**Consultation Response from KC,
Highways Development Management**

2023/90349 adj, 11, Park View, Cleckheaton, BD19 3AN

Erection of detached dwelling

Date Responded: 23/05/2023.

Site Plan 1:100

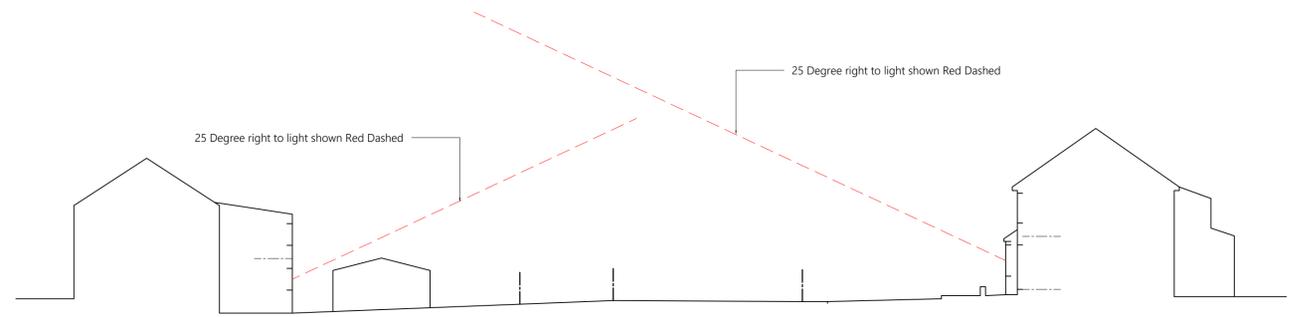
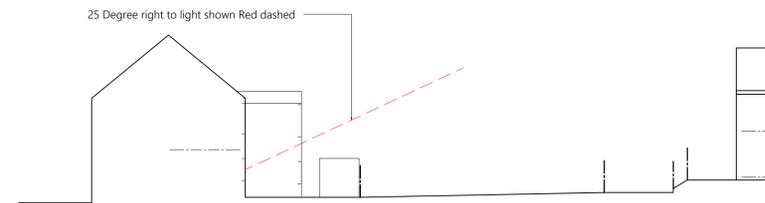
2 Off-street car parking spaces are proposed which meets the recommended parking standards for a 2 bedrooomed dwelling.

The approved vehicle parking areas will need to be surfaced and drained in accordance with the Communities and Local Government; and Environment Agencies 'Guidance on the permeable surfacing of front gardens (**parking areas**)' published 13th May 2009 (ISBN 9781409804864) as amended or superseded.

Any changes to the access within the adopted highway fronting the property, to provide a dropped kerb, will need to be constructed under a section 184 agreement of the 1980 Highways Act (vehicle crossings over footways and verges). You are required to consult the Design Engineer (Kirklees Street Scene: 01484 221000) with regard to obtaining this permission and approval of the construction specification. Interference with the highway without such permission is an offence which could lead to prosecution.
